RFI Item 5 & 6: Biodiversity & AA

Faith Wilson Ecological Consultant (FEWC) prepared the Biodiversity Chapter within the EIAR and the Natura Impact Statement to support a planning application for a proposed Large-Scale residential development (LRD) and Creche on lands at Barrysparks and Crowscastle, Swords, Co. Dublin (ref. LRD0055/S3E) on behalf of Bovale Developments Unlimited Company.

Fingal County Council (FCC) issued a Request for Further Information (FI) seeking clarification on various items, including those associated with Item 5 (and more specifically, with the biodiversity aspects) and Item 6. A response to same has been prepared by FEWC.

Silt Fence Location - Plan Layout
SCALE 1:1000

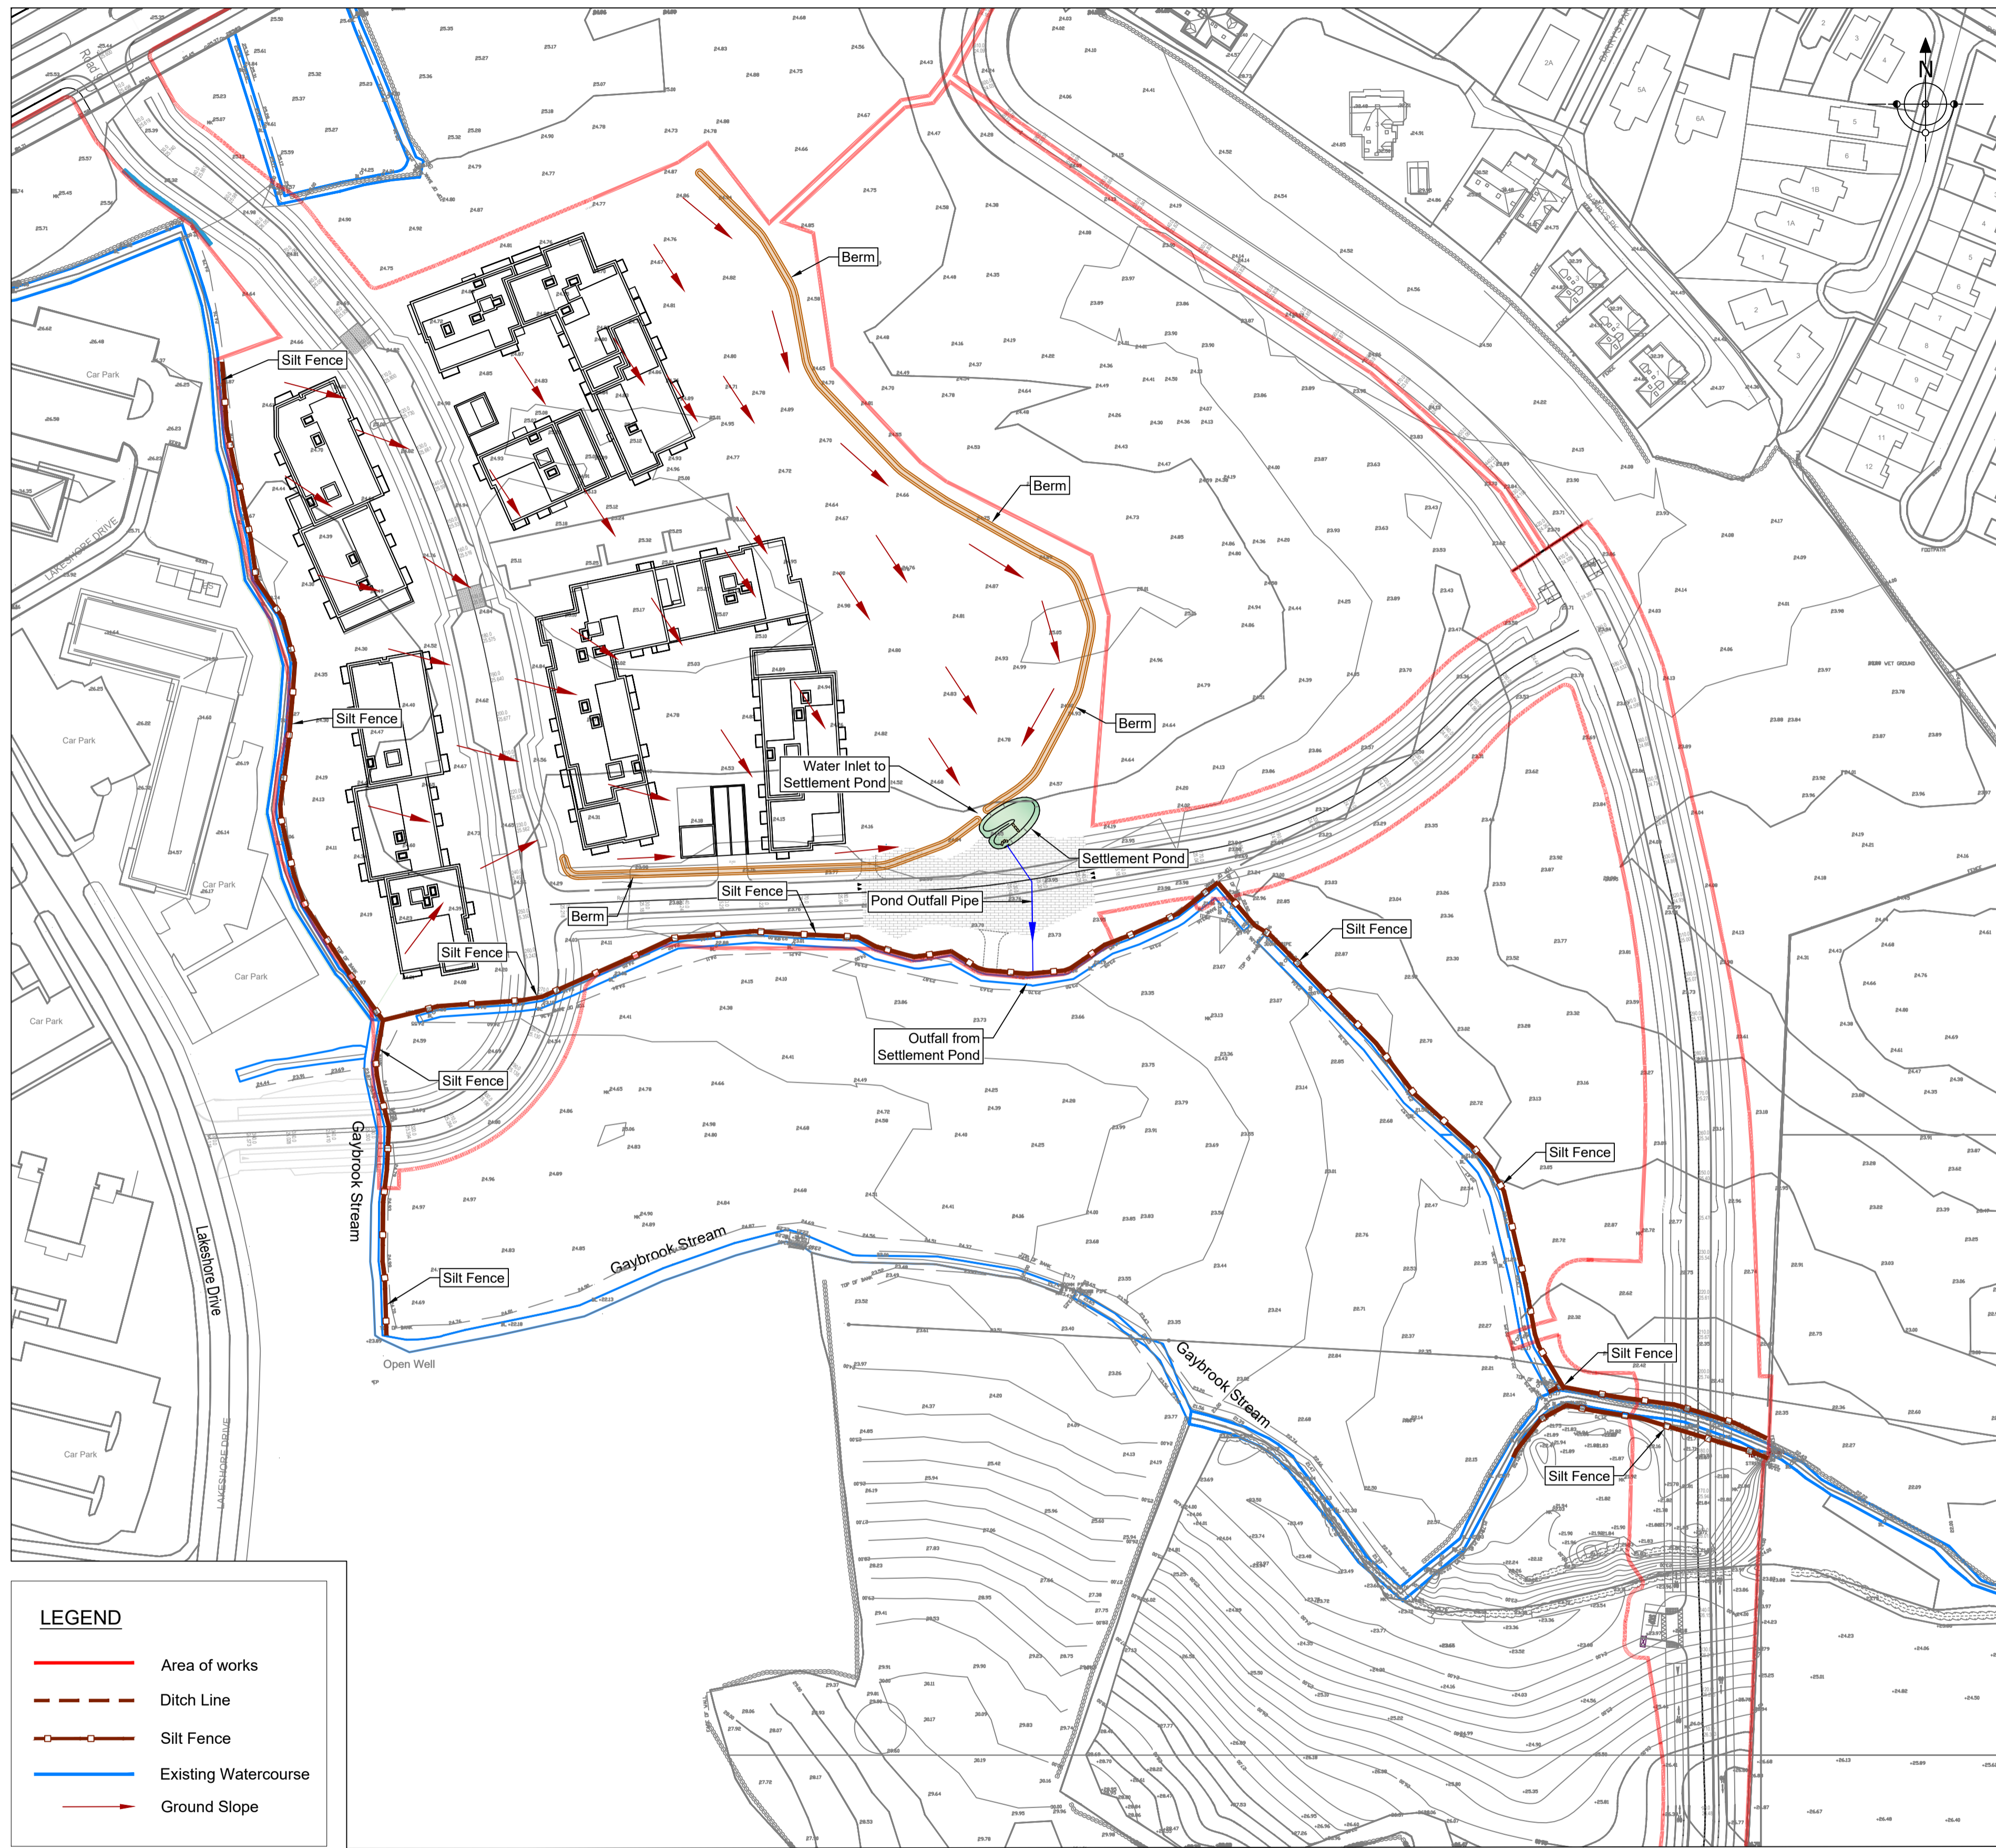
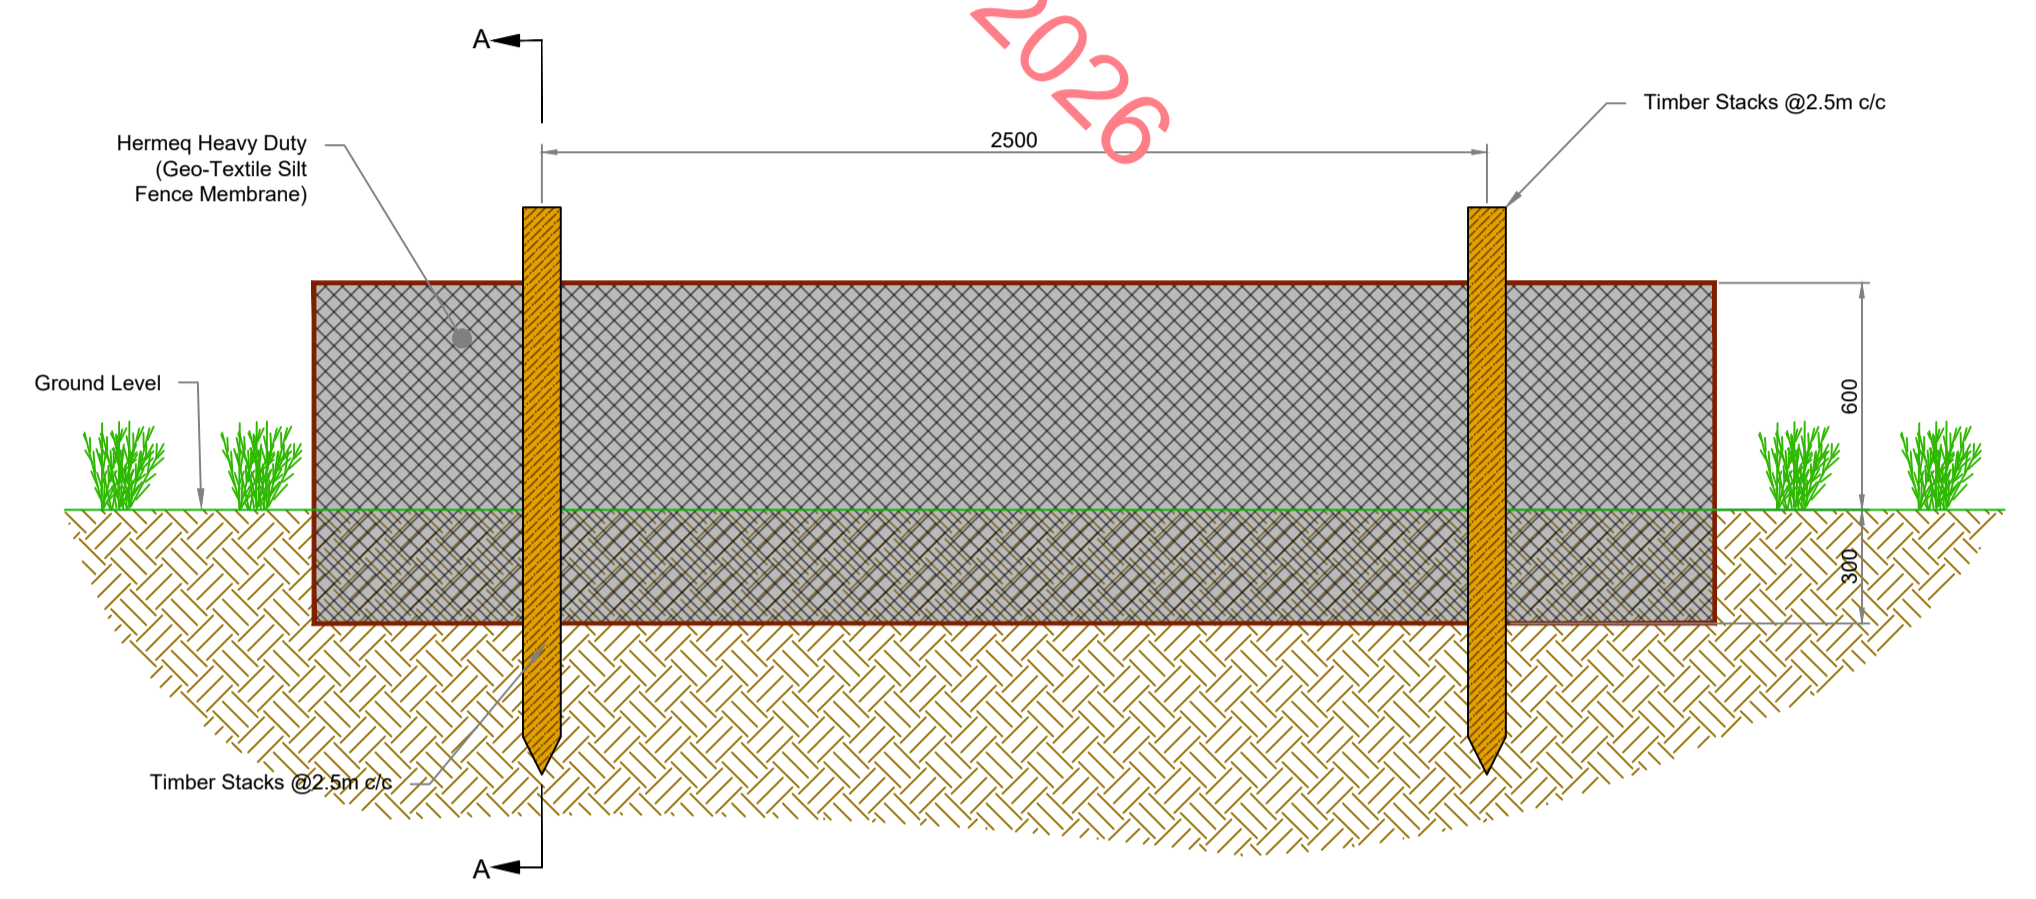
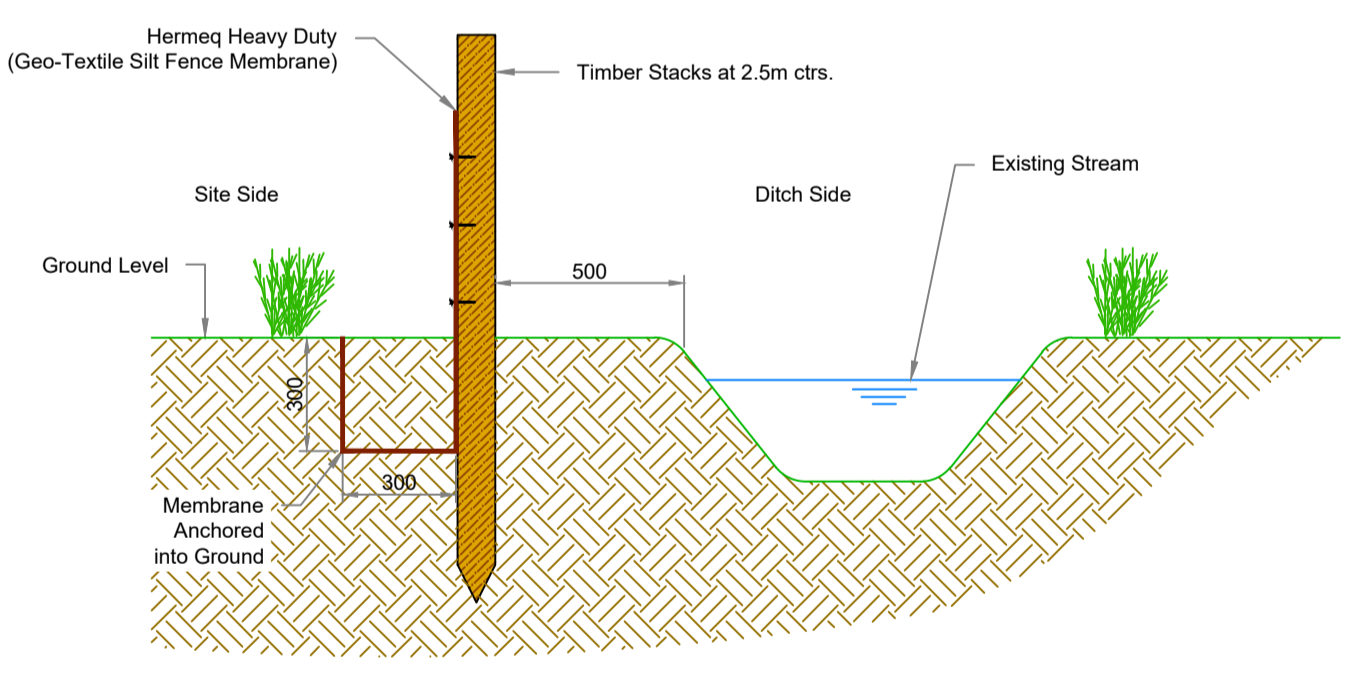
- xi. The Applicant is requested to clarify why the OCEMP does not include the mitigation measures set out in the Biodiversity Chapter. Additionally silt fencing is provided as part of sediment control in Section 4.7.2, however silt fencing is not included for in the OCEMP.**

The OCEMP has been revised and updated to include the mitigation measures contained in the Biodiversity chapter of the EIAR.

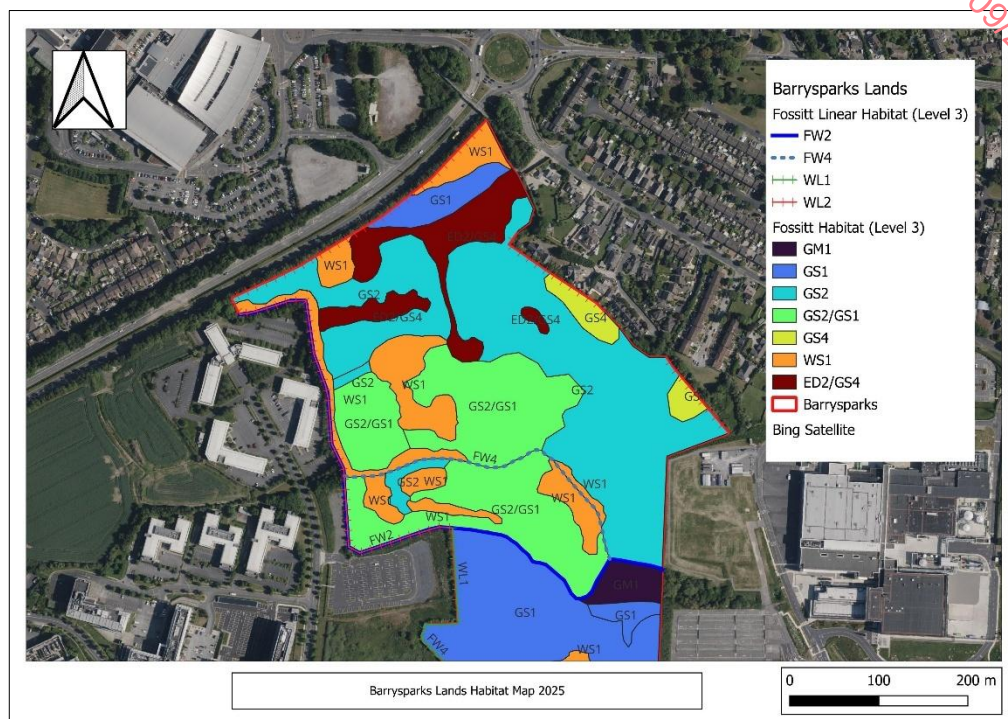
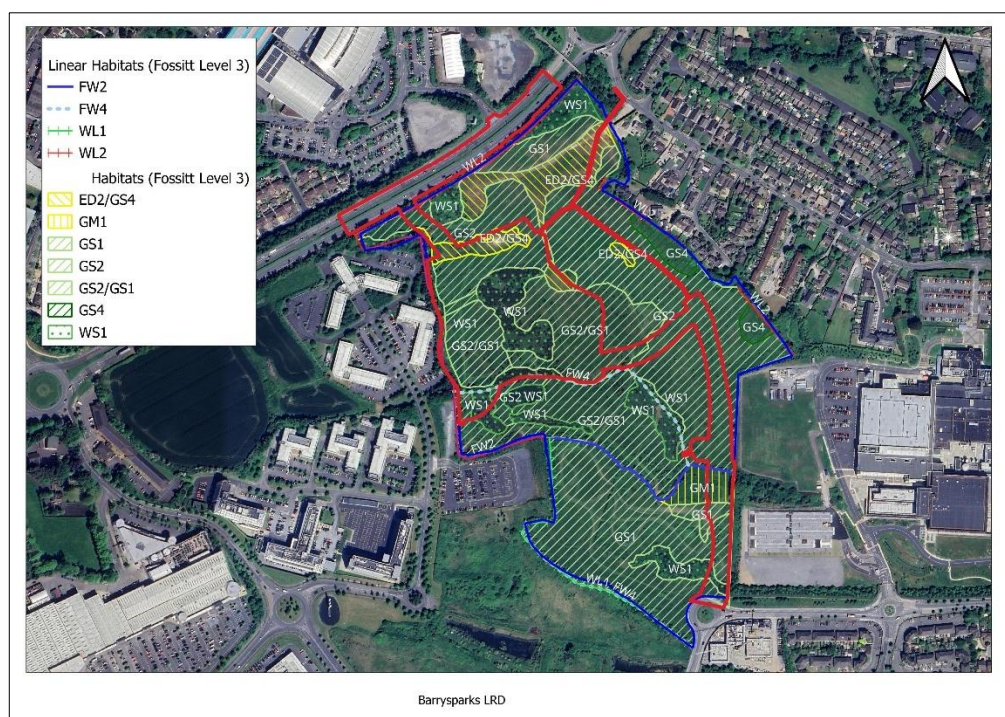
- i. The Applicant is requested to provide a Habitat Map which clearly shows all the linear habitats (e.g. hedgerows and treelines) of the application site.**

A habitat map of both the Barrysparks LAP lands under the ownership of Bovale and the application site were included within the EIAR chapter (**Figure 4.8** and **Figure 4.9**) – see below.

These figures show the habitats present on the site (scrub, grasslands, areas of open and recolonising bare ground) mapped to Fossitt level 3 including linear habitat features (drainage ditches, watercourses, hedgerows and treelines) and the site boundary as appropriate.

They are presented again in **Appendix 1** with the red line boundary of the application site and the blue line boundary of the LAP lands omitted for clarity as these may have obscured the perimeter linear habitat features.
